870 Congress St

From: Glenn Harmon [mailto:gharmon@portlandmaine.gov]
Sent: Wednesday, March 14, 2018 3:38 PM
To: Rodenhizer, Christopher R. - (BOS) <crodenhizer@tcco.com>; moreld@mmc.org
Subject: 870 Congress St

A1-0

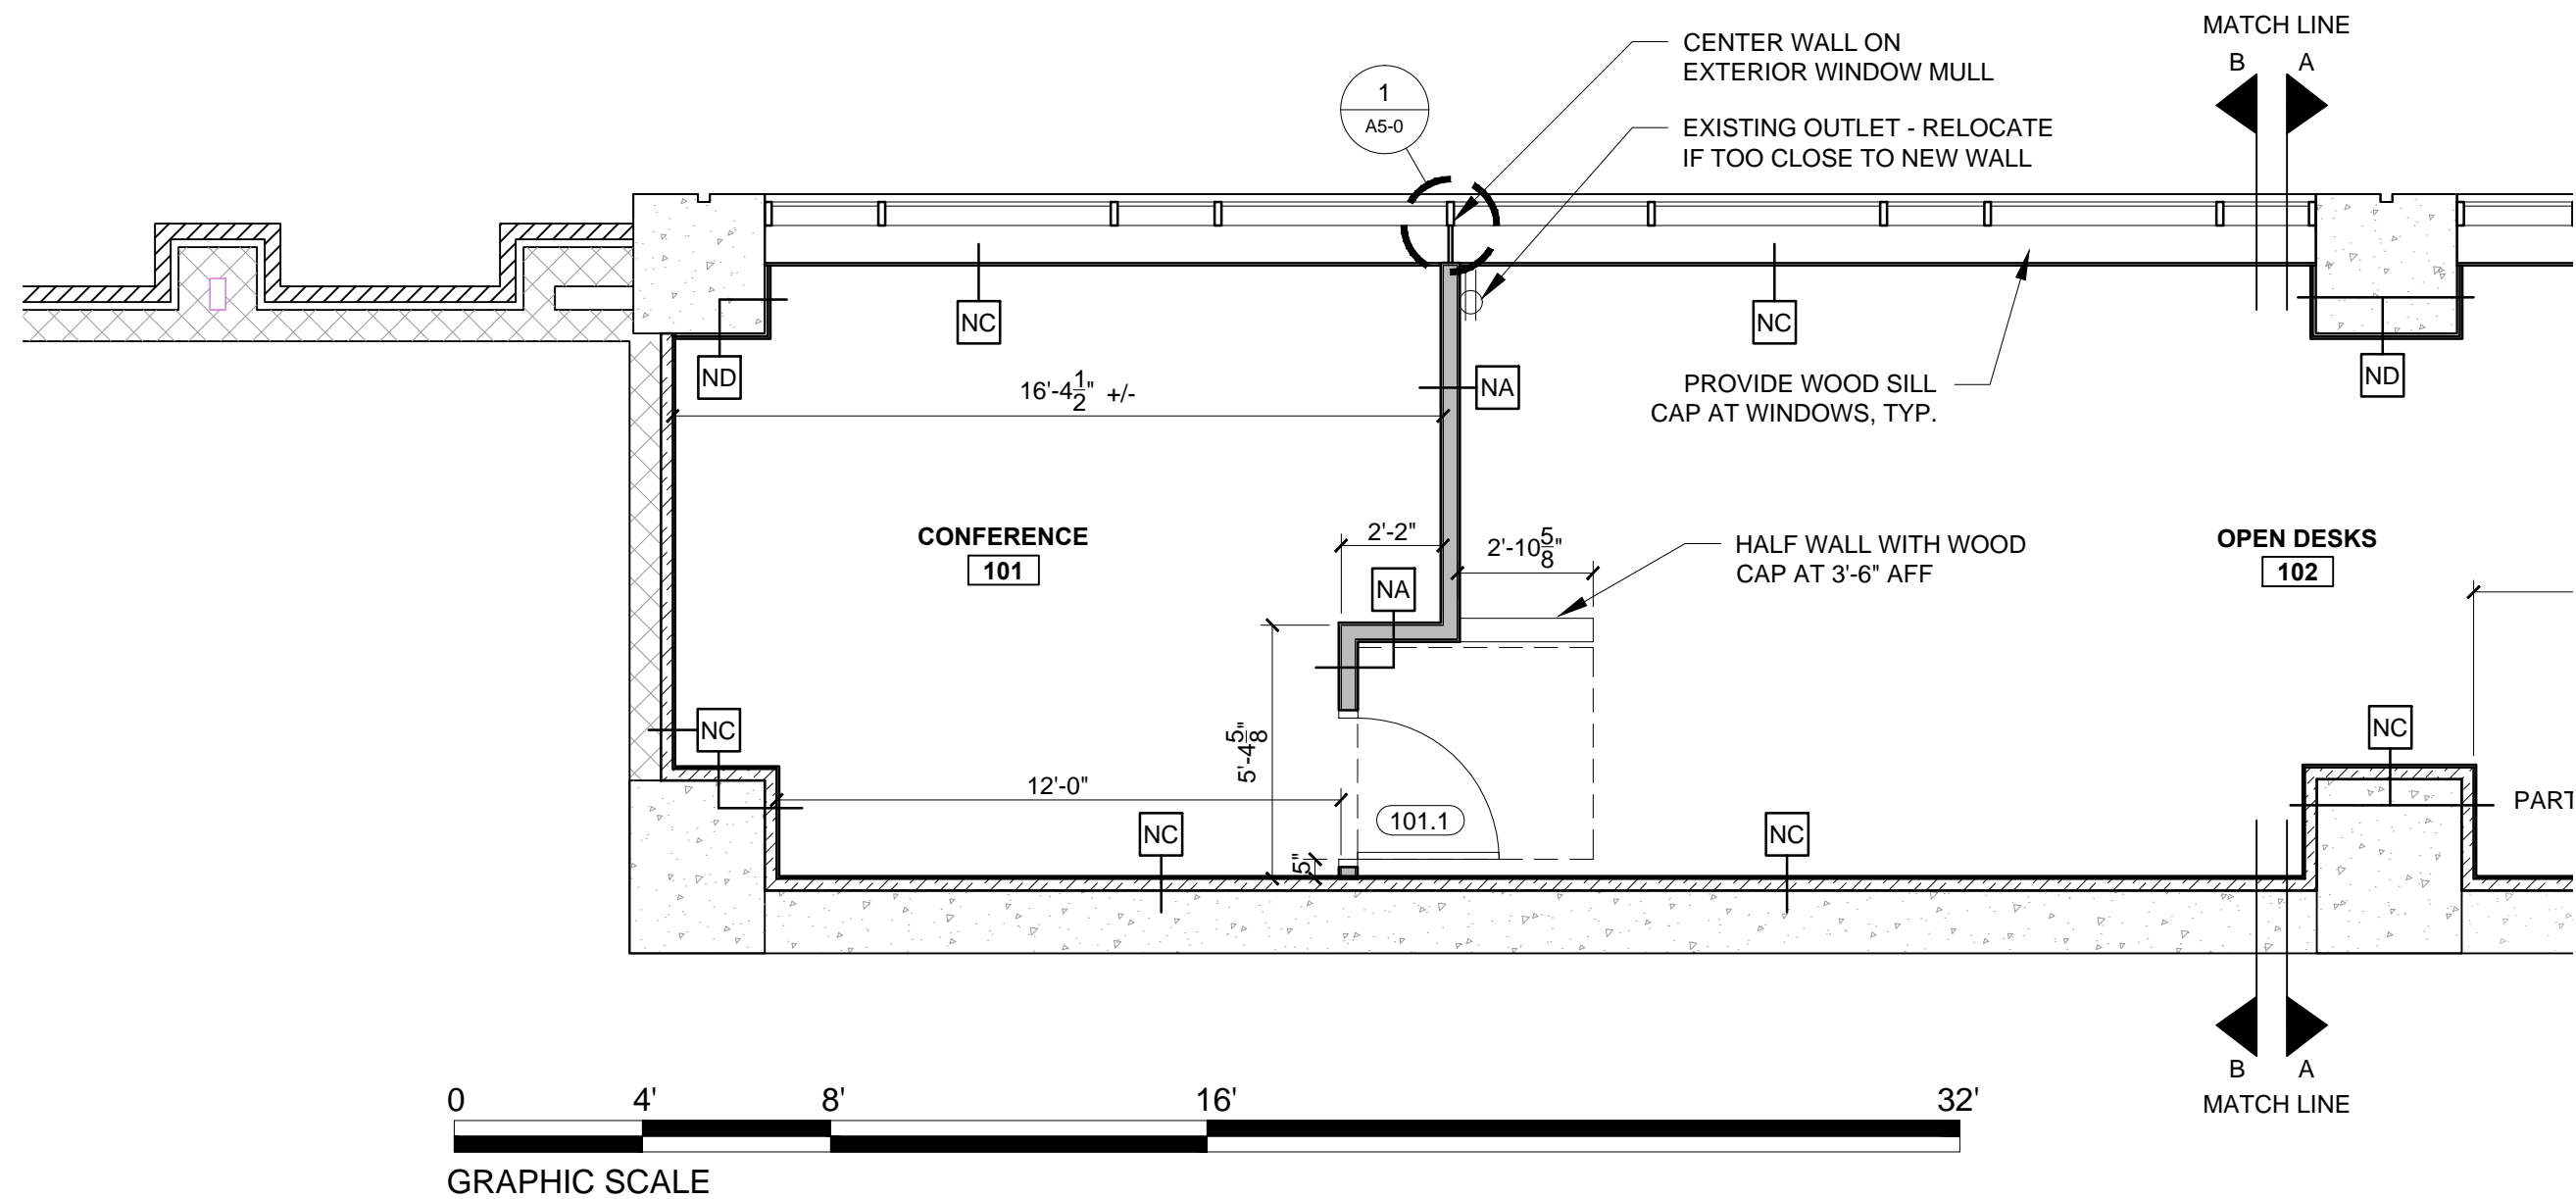
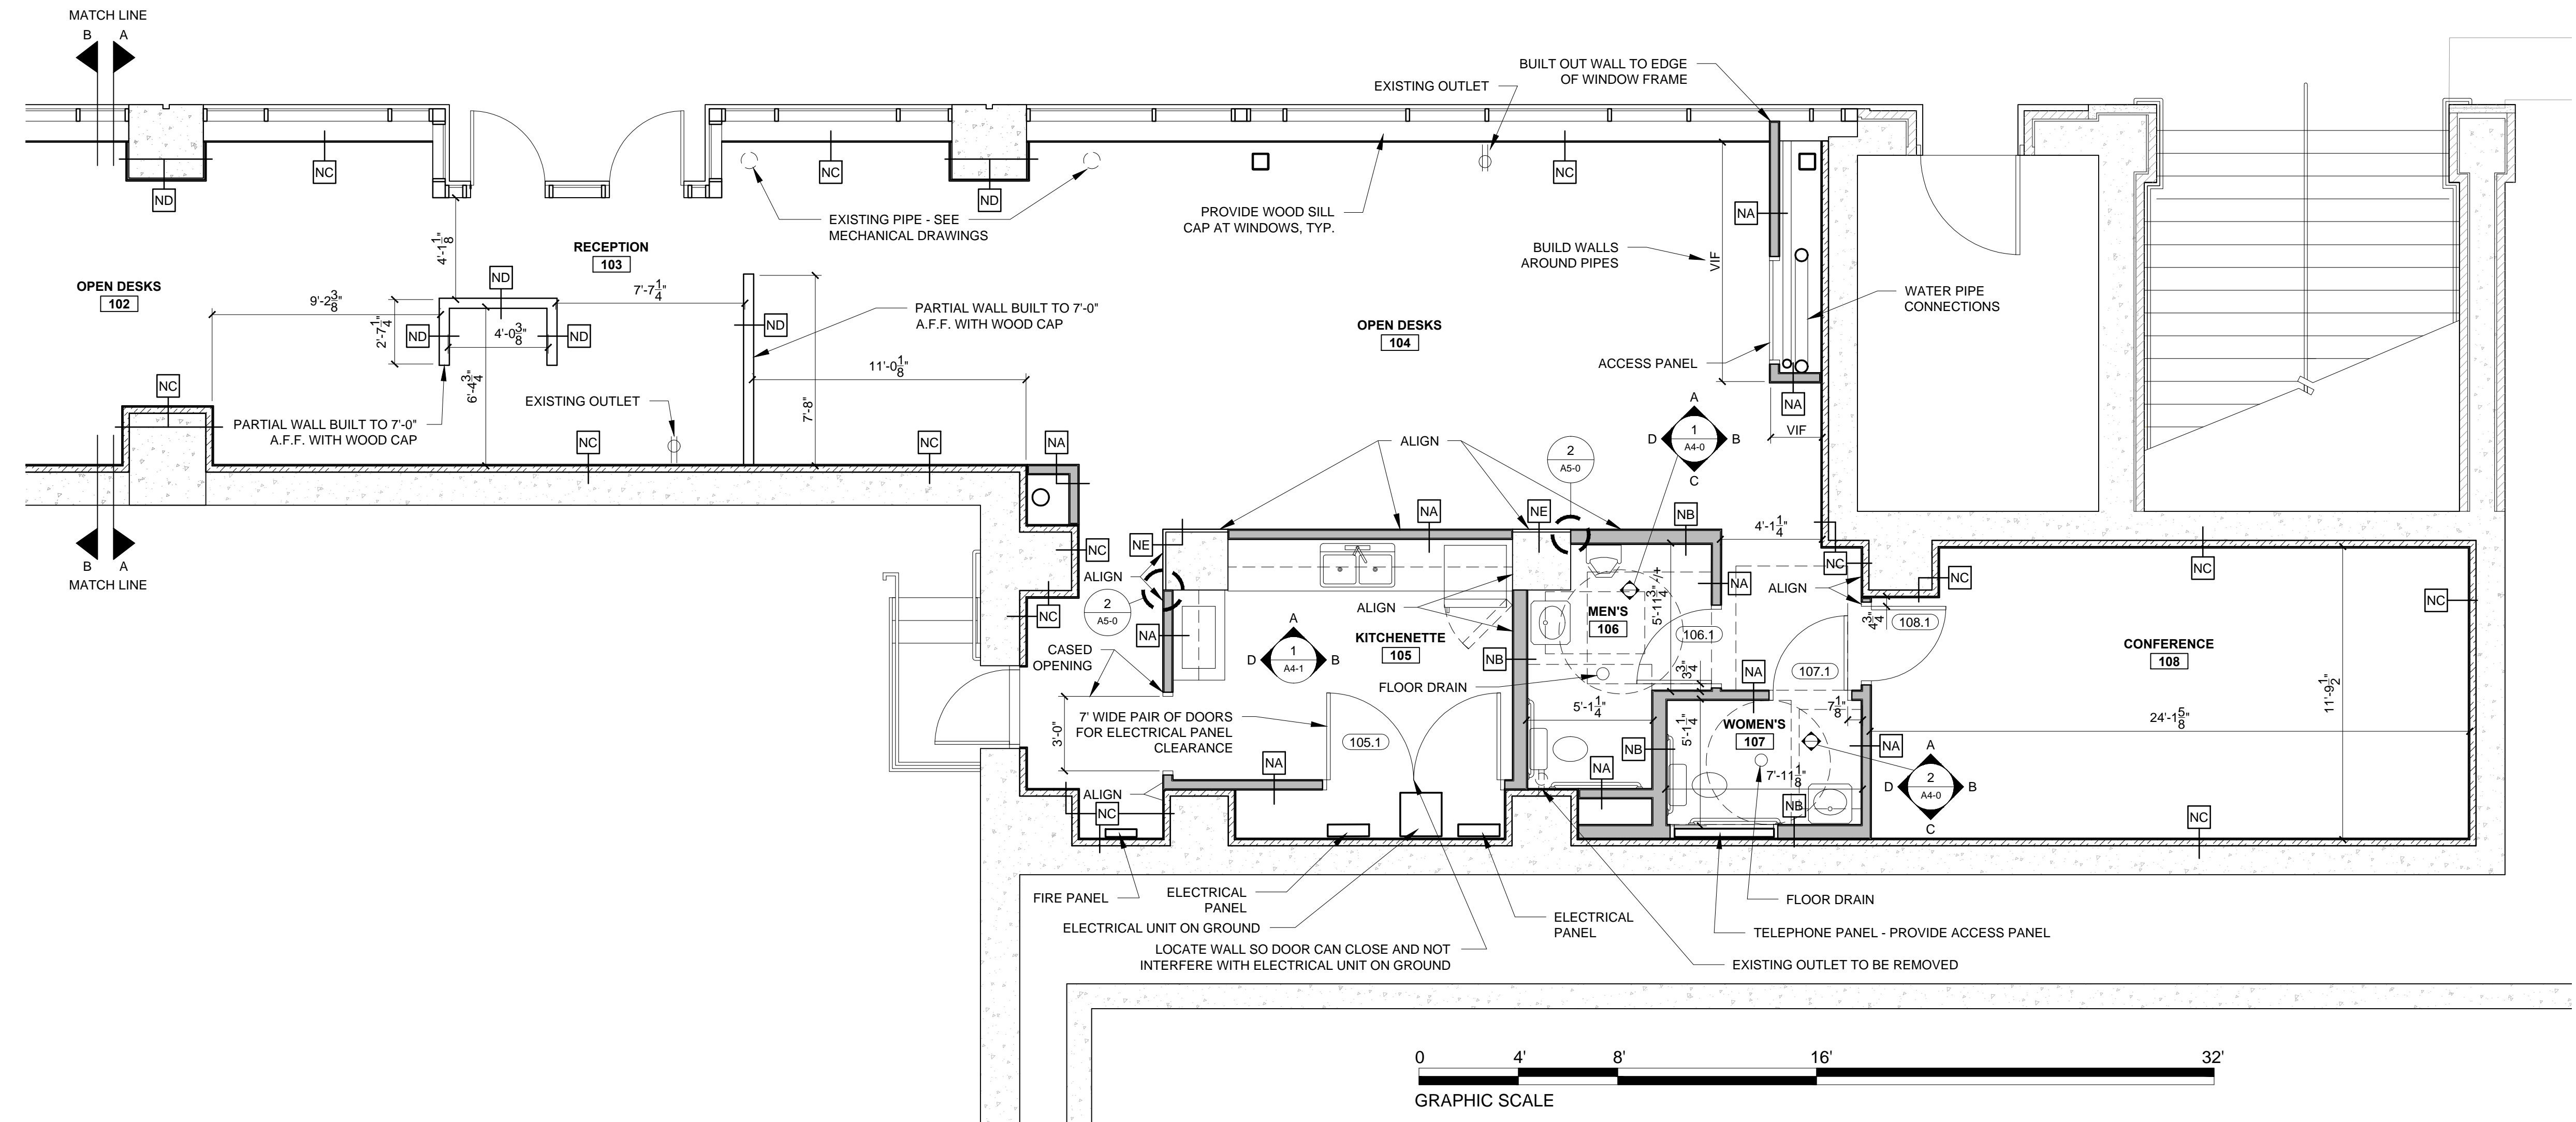
- 1.) We eliminated the small 3' half wall

- 2.) We added a light gauge post to the 7' tall wall for support

A4-1

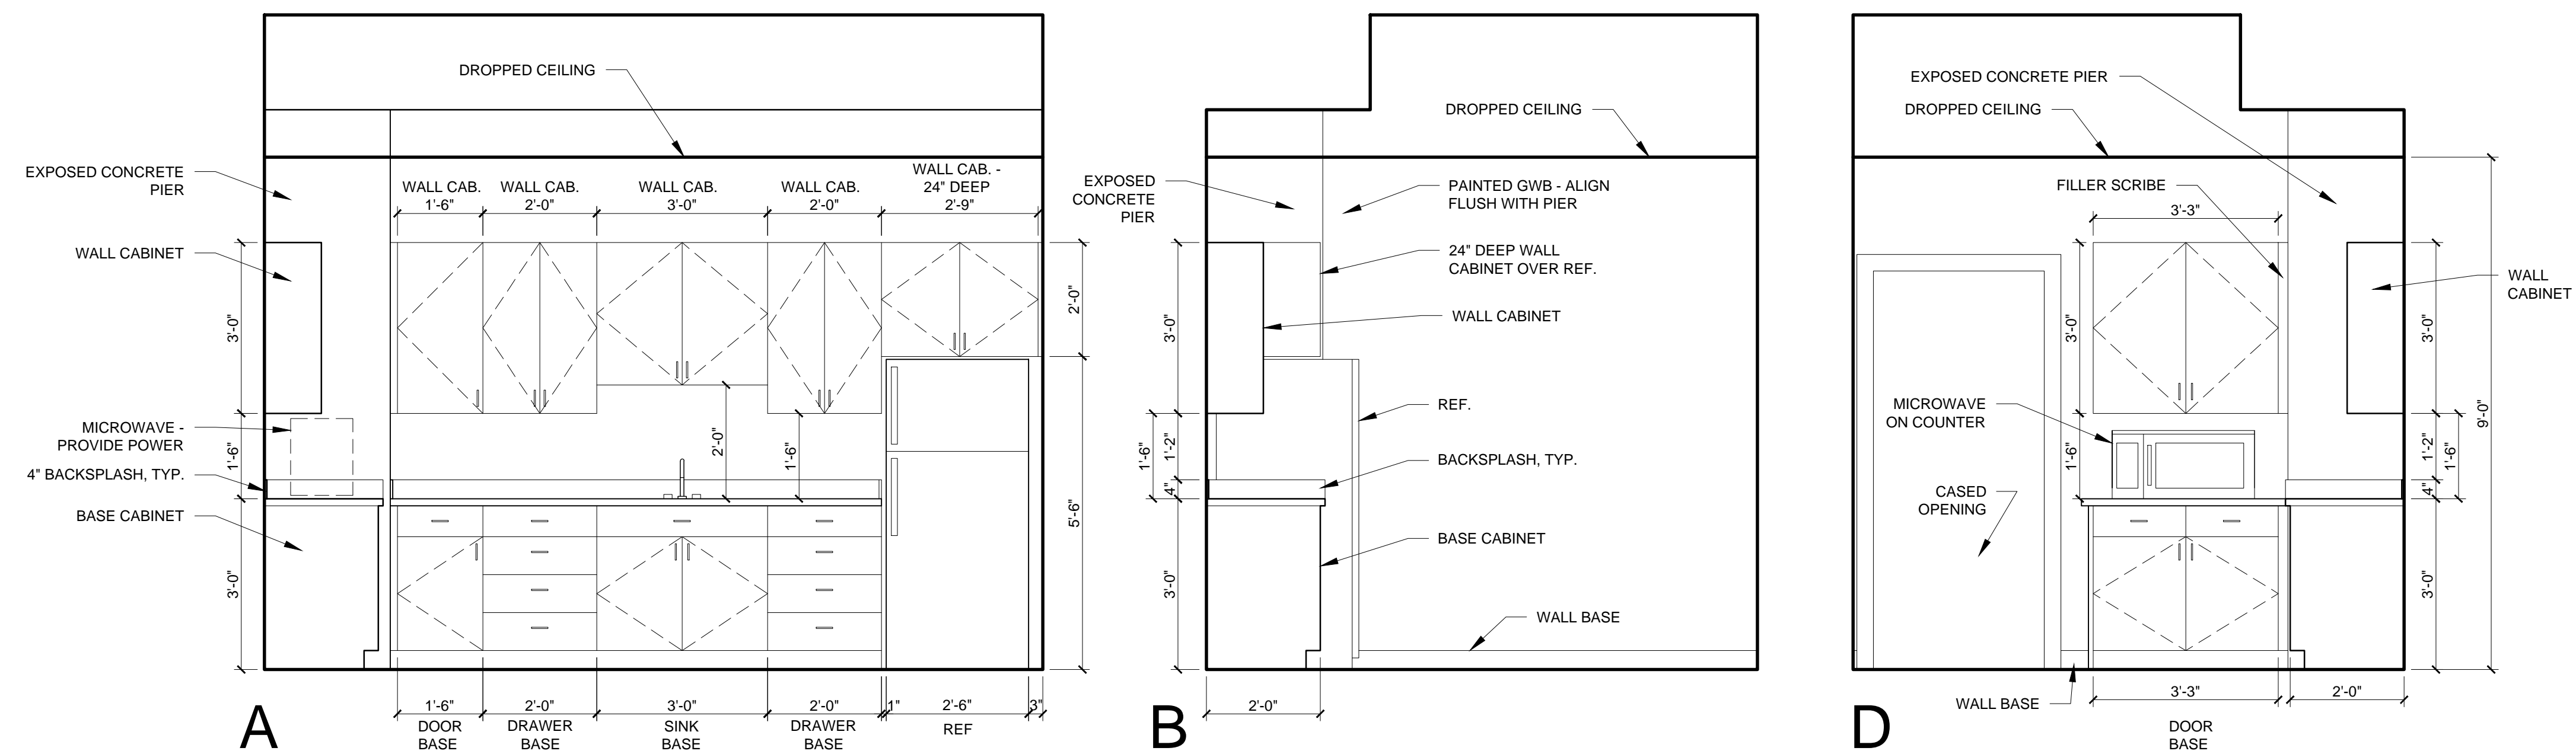
- 4.) We have revised the kitchen for ADA accessibility see the interior elevation on A4-1.

G1-1

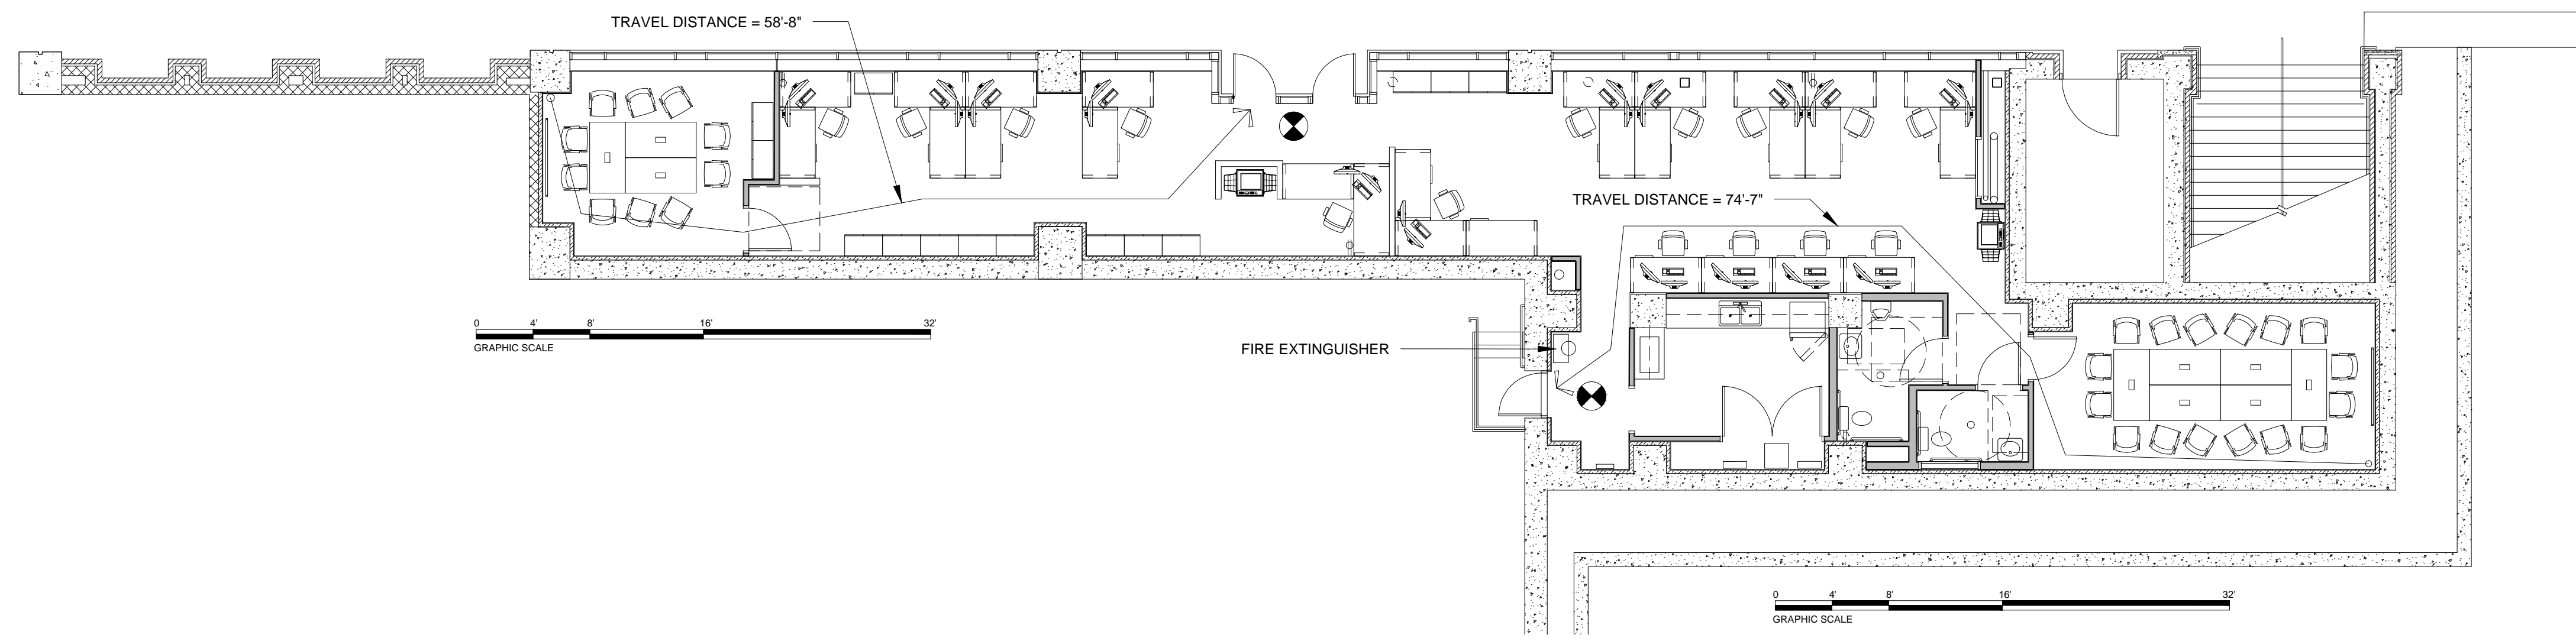
- 3.) The door out the rear of the space leads into the parking garage which then leads to an egress exit to public way.
